Date 25<sup>th</sup> January 2011.  
App No. 2010/ 1483/ Ful

**Re; Land to side of existing Dwelling, Wellfield Road, Barnsley. S75 2AL**

SITE AREA = 1300M² (1/3 ACRE)

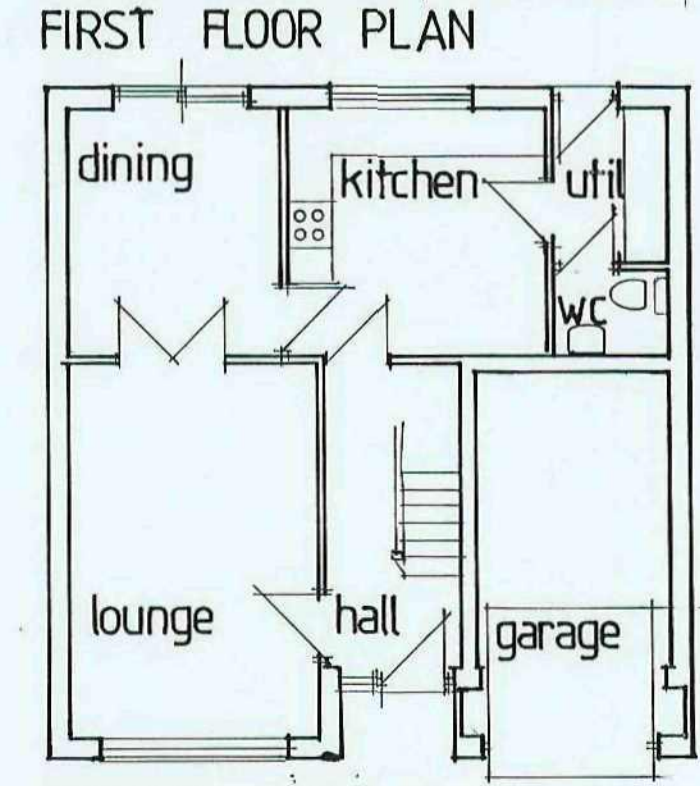
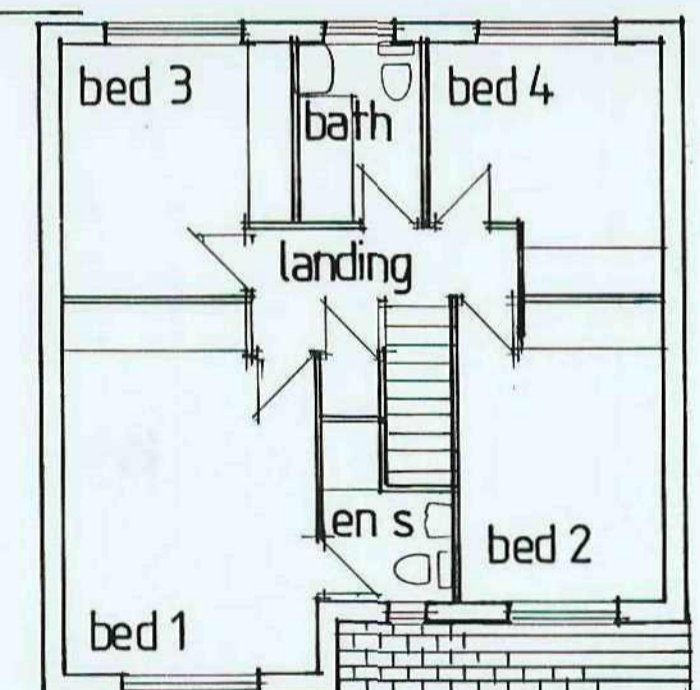
Thanks for your E – Mail last week and your sympathy with my recent situation. In regards to your request to provide a turning facility within the site I have now amended the site layout to incorporate a reversing facility across onto the existing driveway which will allow the emerging traffic to exit the site in forward gear . Trusting this meets with your approval.
